**Application by NNB Generation Company (SZC) Limited for an Order Granting  
Development Consent for The Sizewell C Project**

**Procedural Deadline 3 Submission**

## Appendix A: National Trust technical comments on design details and plans for the Hard Coastal Defence Feature (HCDF)

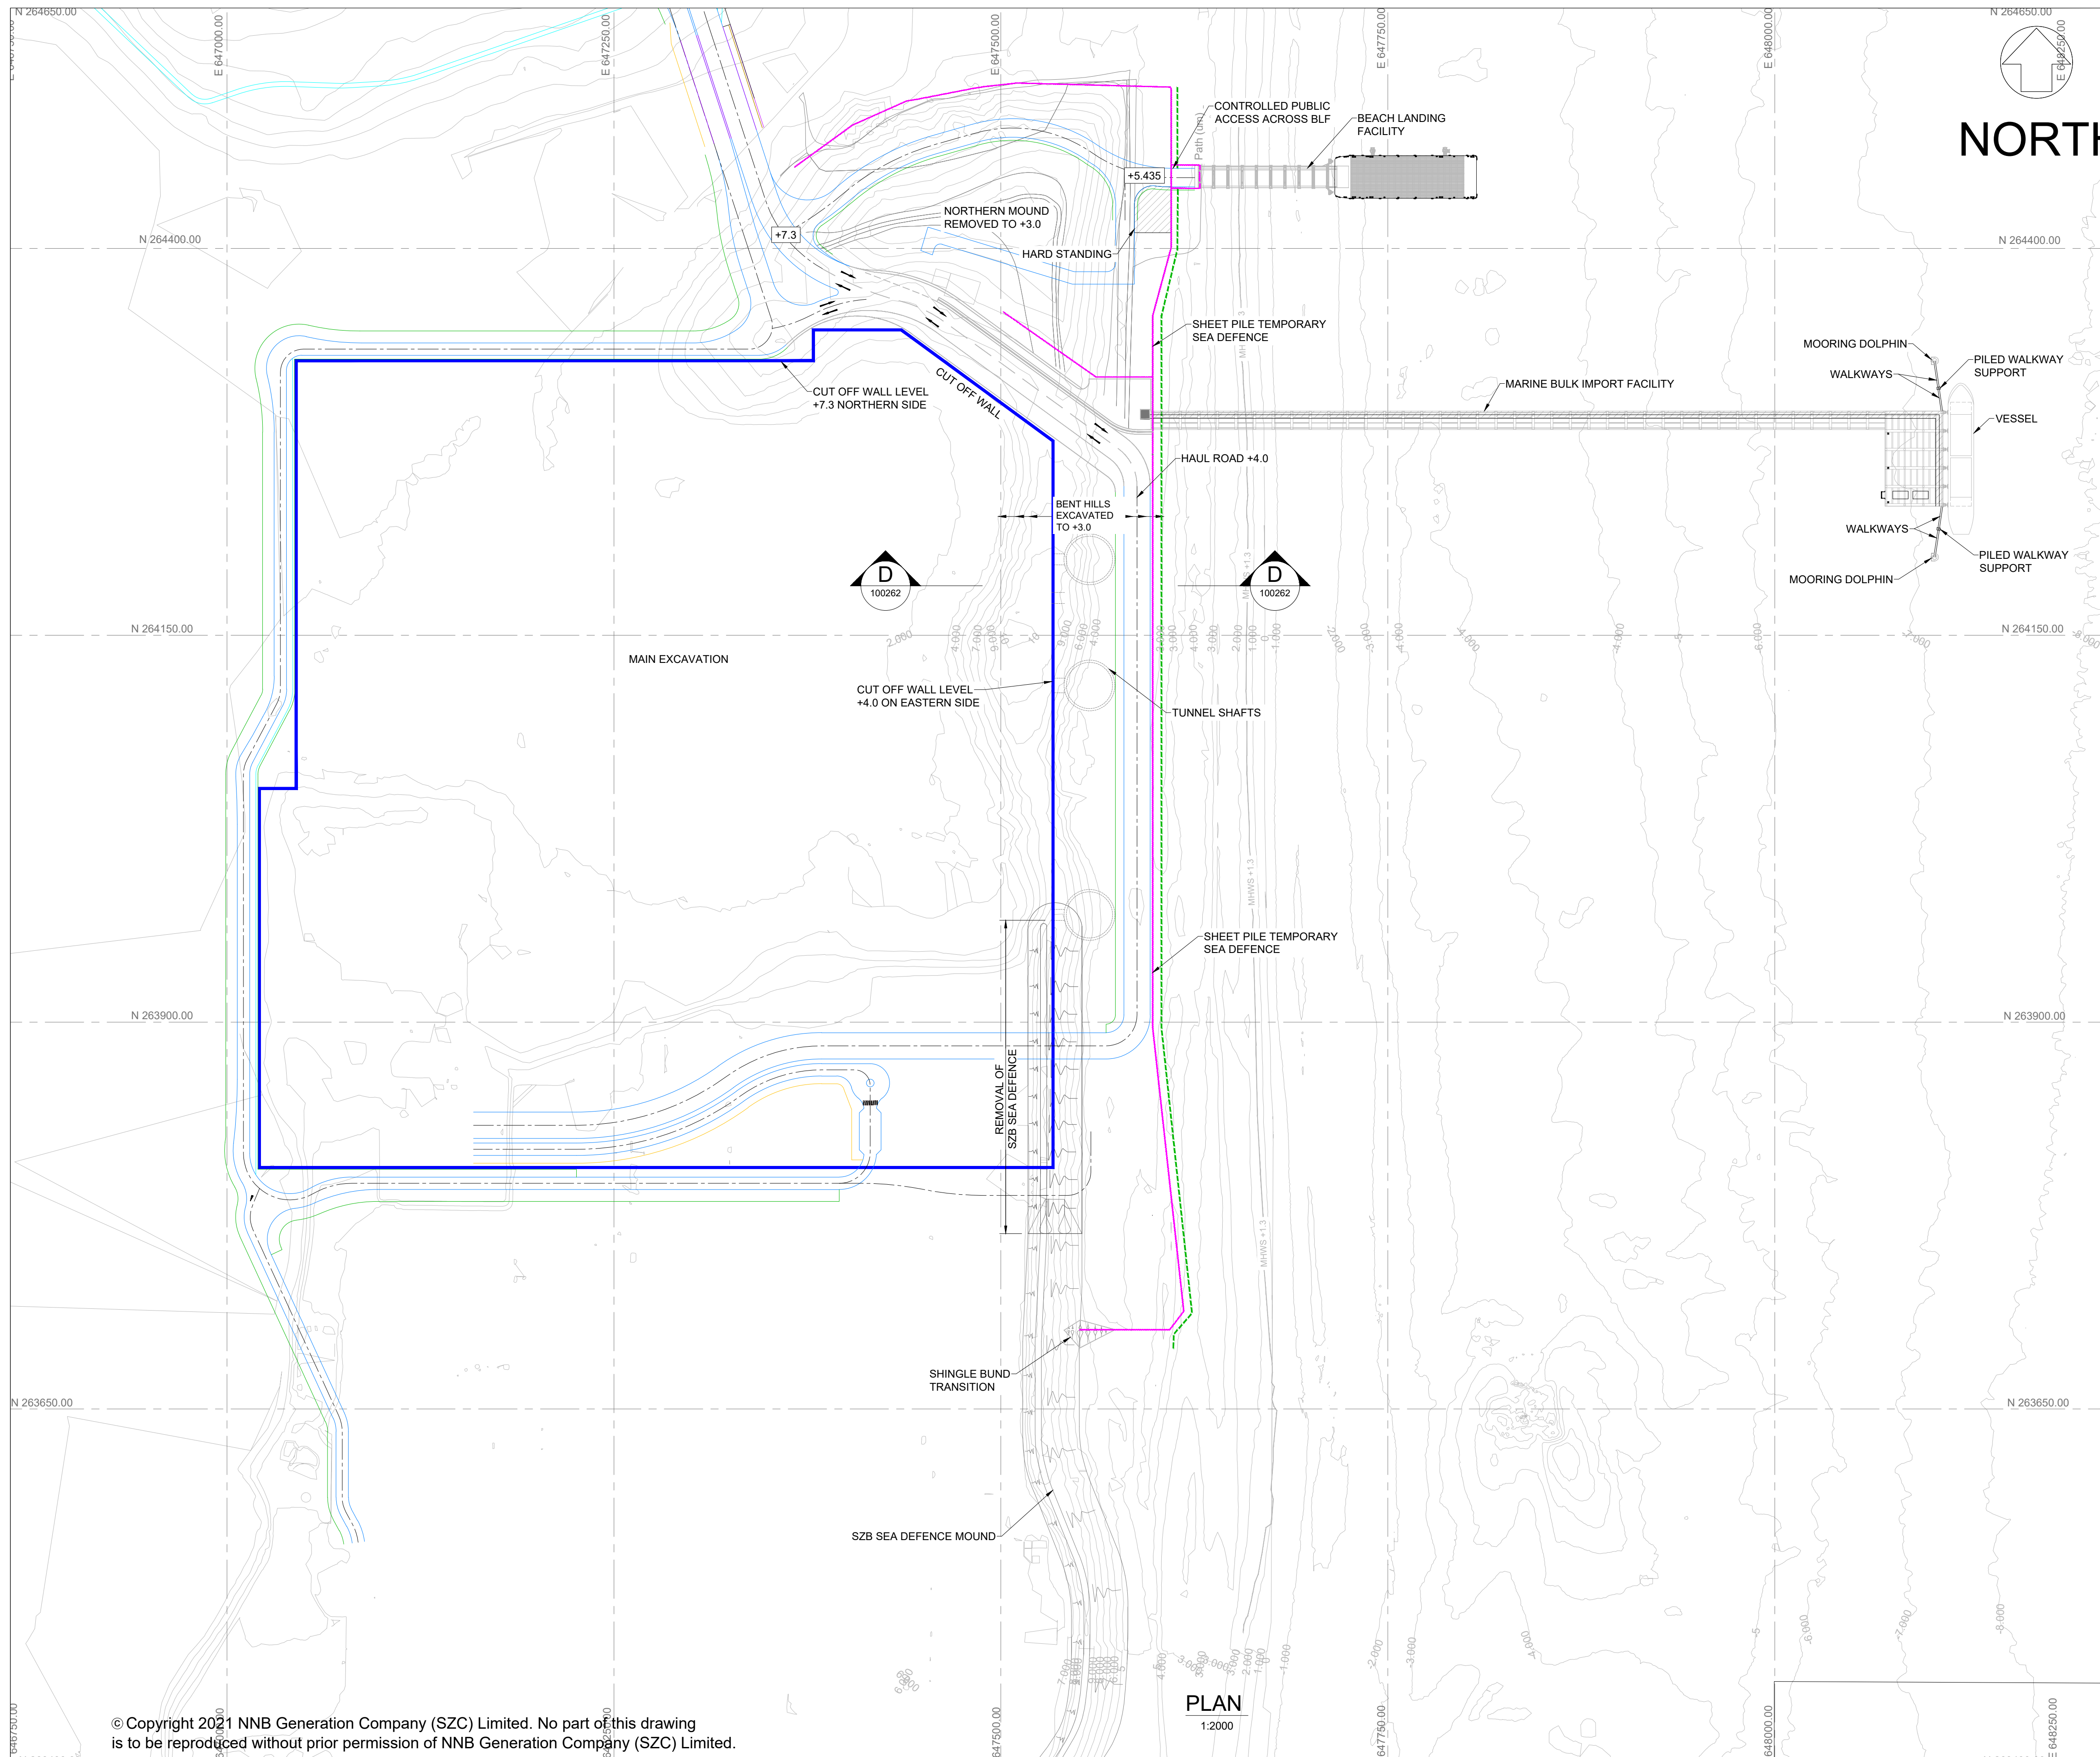
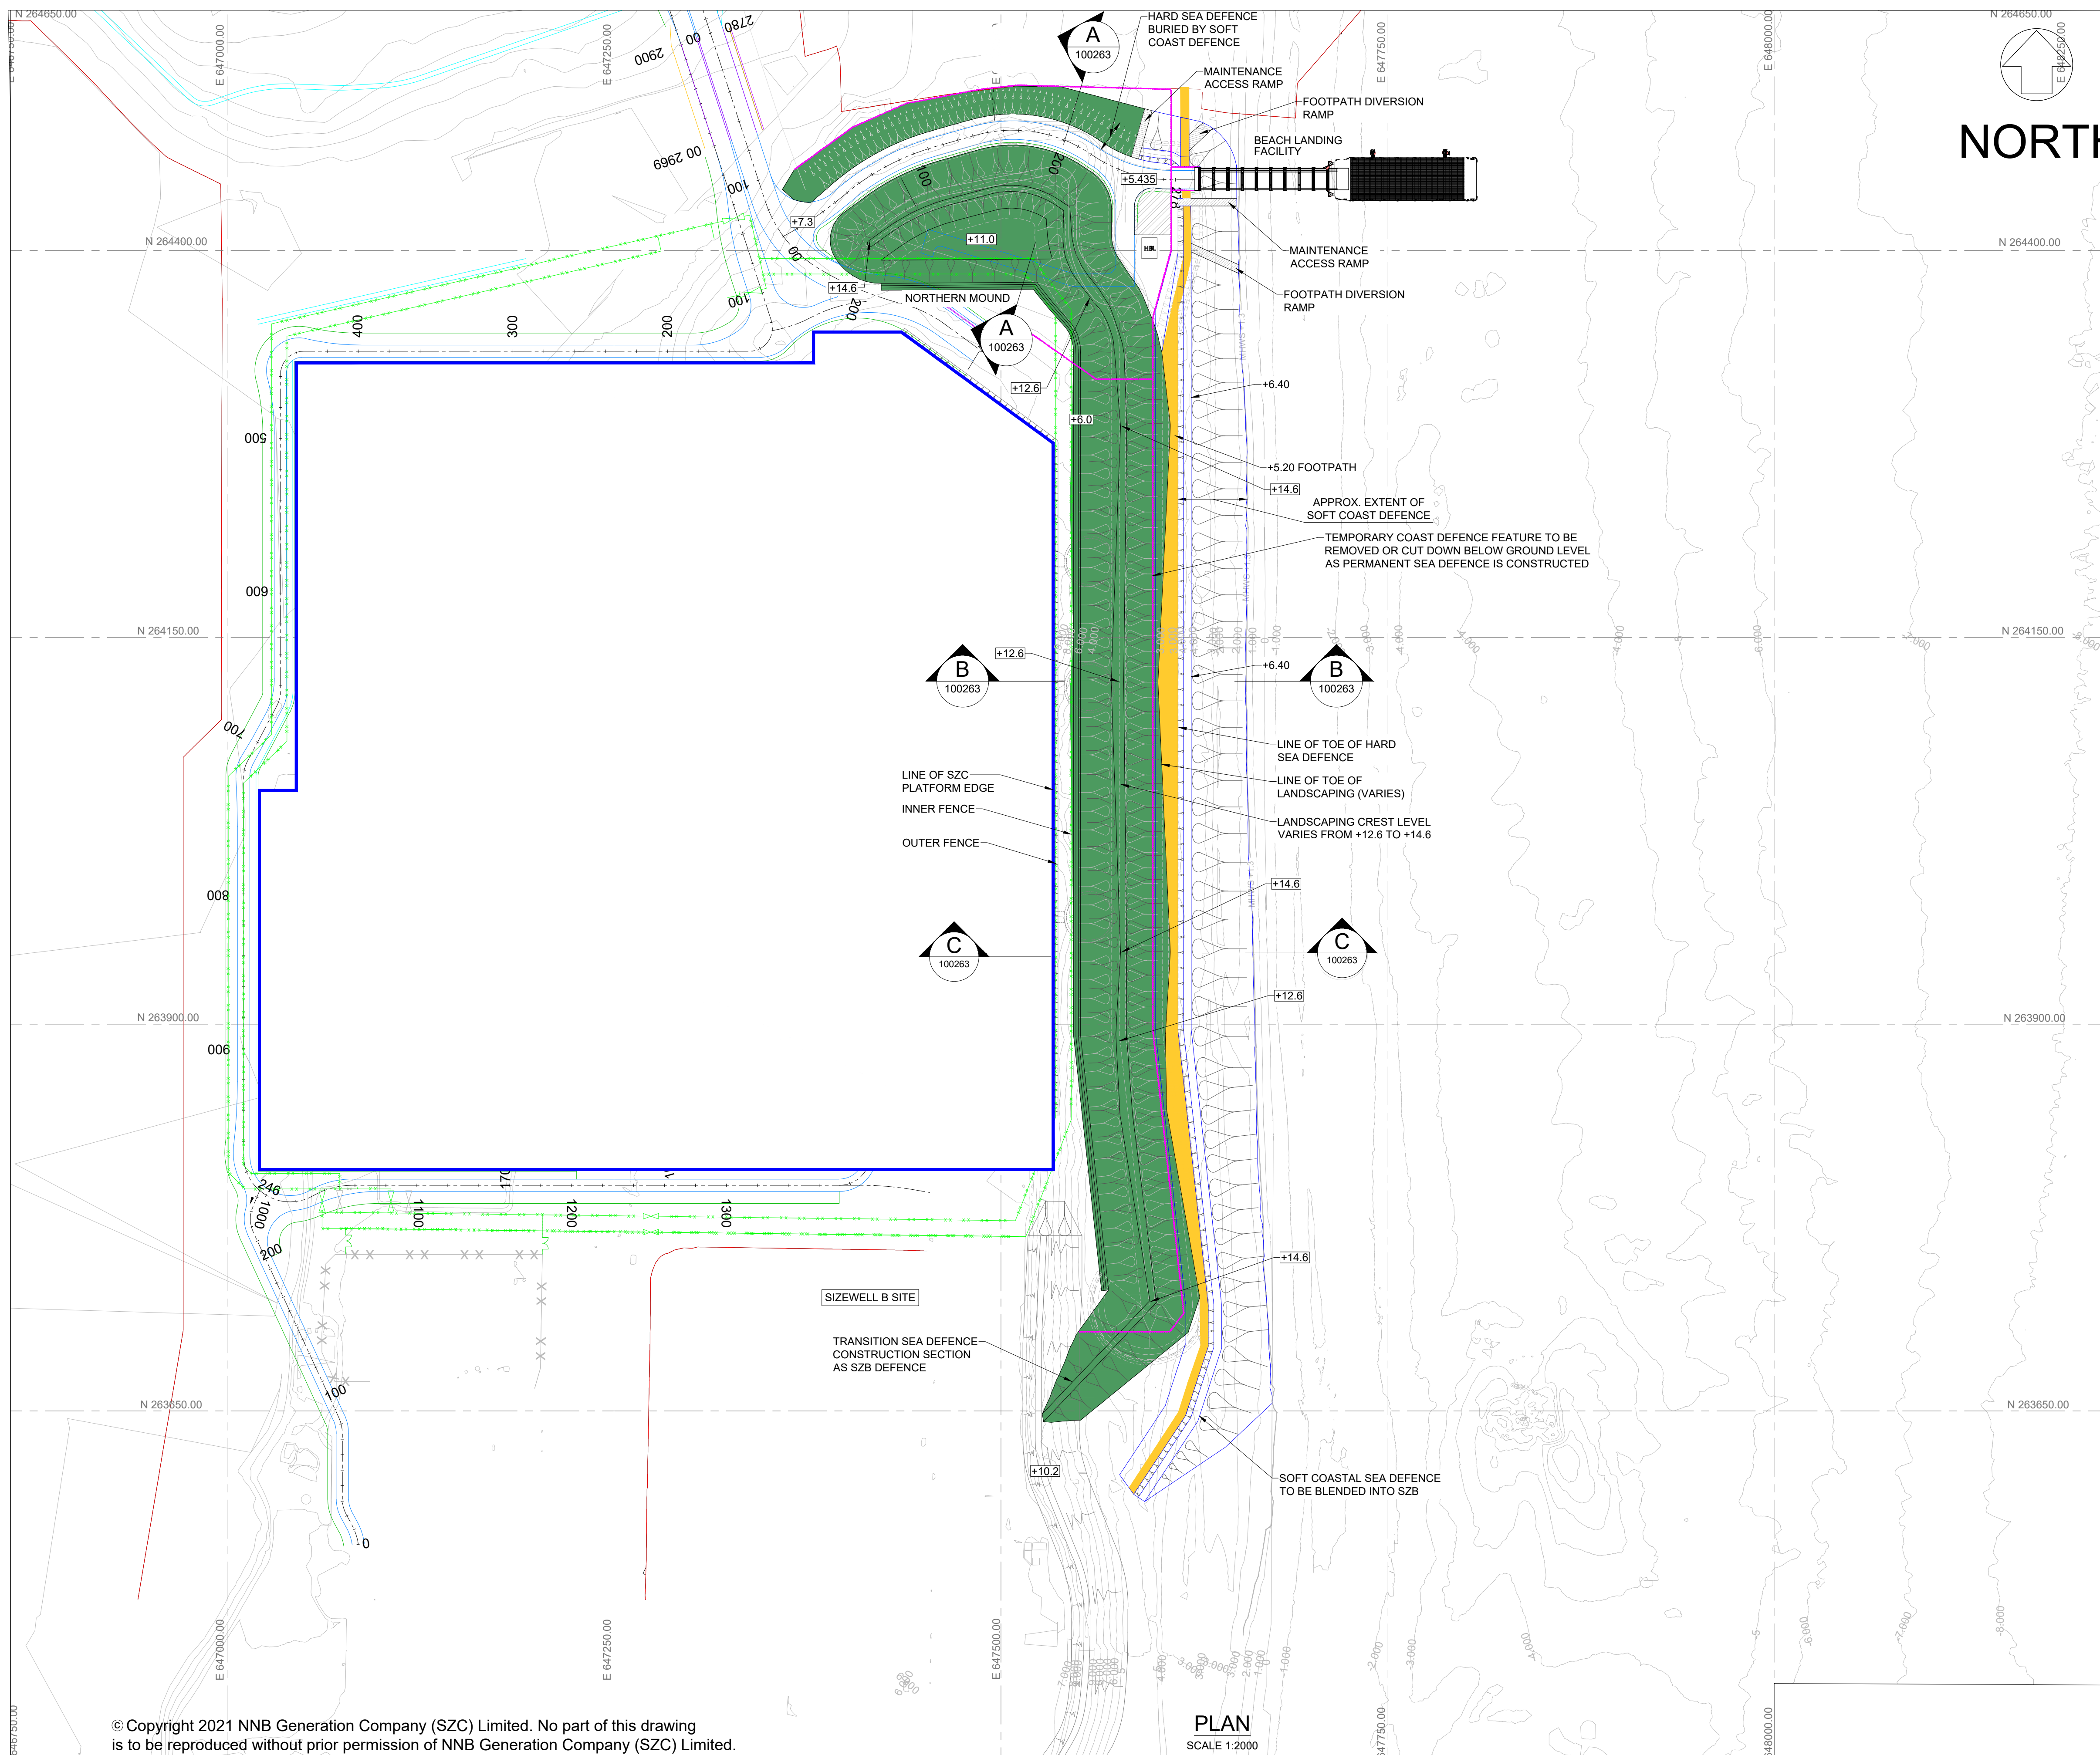
8. Figure 3-1 shows both the temporary sheetpile sea defence and the permanent HCDF, both are seawards of the shoreline thus forming a hard promontory on the coast. Within the HCDF there is also a shallow bay in the design along this frontage (the SZC frontage declared at around 750m in length) with promontories at each end; it is possible the shallow bay form aims to retain sediment between the created headlands which might be beneficial in reduction of losses of the SCDF sediments but these headlands are likely to be more disruptive to longshore sediment movement and so have a greater impact to the adjacent coastline (both north and south of it) and this is likely to become more pronounced in the long term (which is now extended to 2140) as a result of the fixed nature of the HCDF whilst the surrounding coastline is soft in nature.
